Re: D&B U Sell It at 401 Unser Blvd. and 8530 Bluewater Rd. NW  
Erosion and Sediment Control Plan  
Engineer's Stamp Date: 6/26/2024 (K10E066)

Based on the information provided in your submittal, received on 6/27/24, the above-referenced ESC Plan cannot be approved for a Building Permit until the following comments are addressed.

LANDSCAPE PLAN

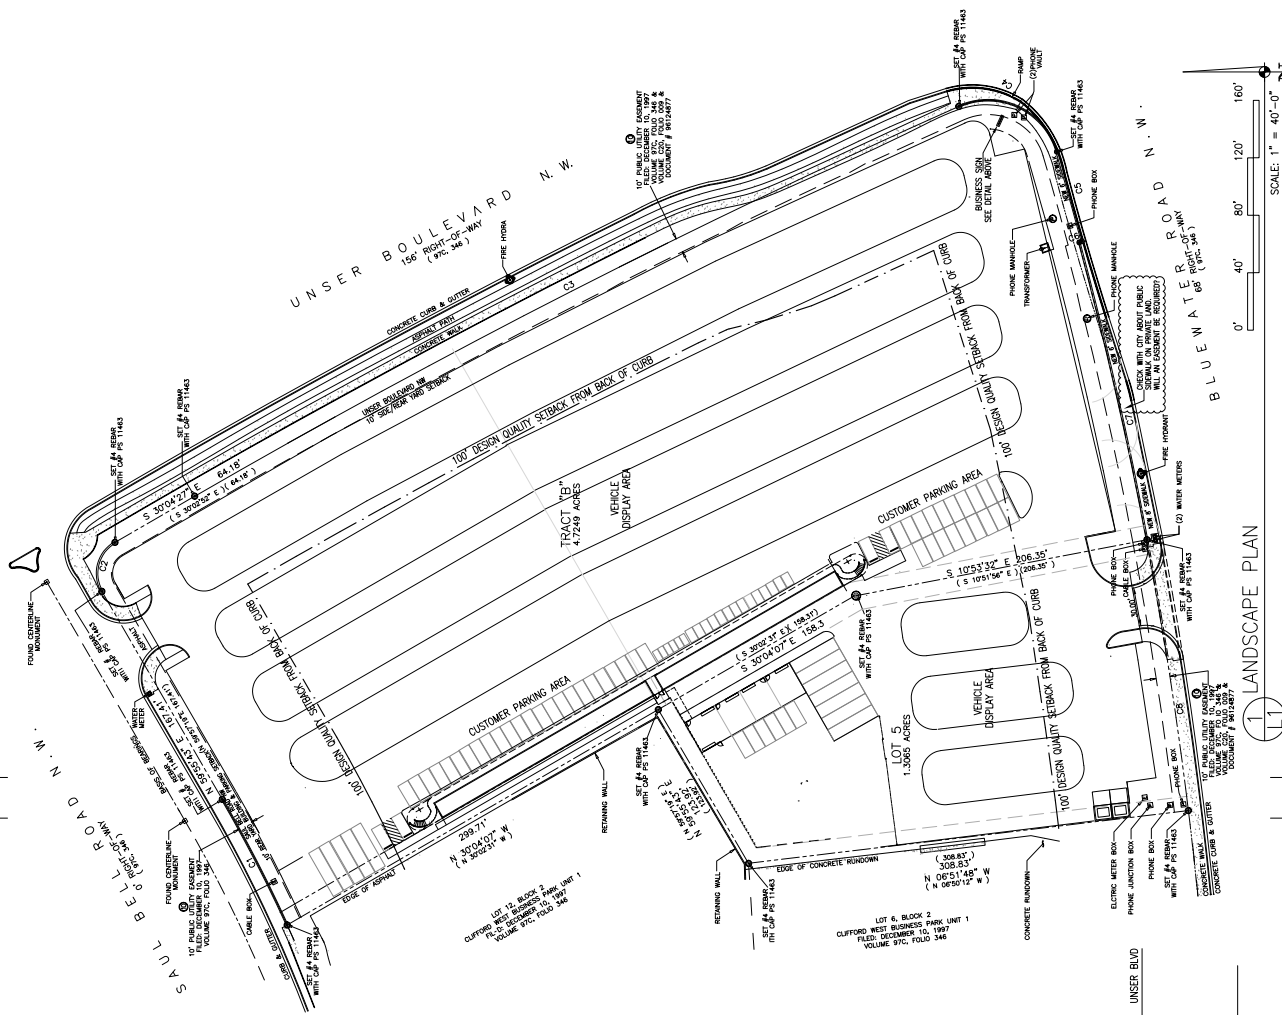
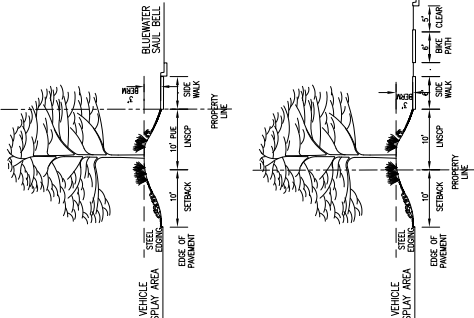
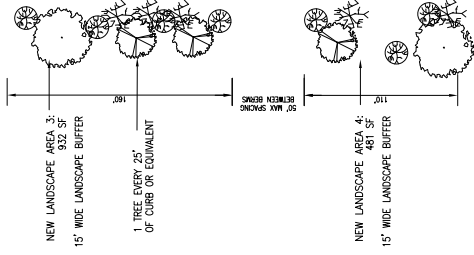
4. The SWPPP must include site-specific interim and permanent stabilization per CGP 9.6.1.c.i. The Landscape Plan can satisfy this requirement if it is modified to show the location of all vegetative cover. The sheet with the architect stamp dated 11/29/23 doesn't show the locations of each different type of landscape cover. It should be revised and resubmitted separately from the ESC Plan with the application to the Stormwater Quality Section of the Planning Department and included in the SWPPP. Provide specifications on the ESC Plan for any disturbed areas not covered by the Landscape Plan.
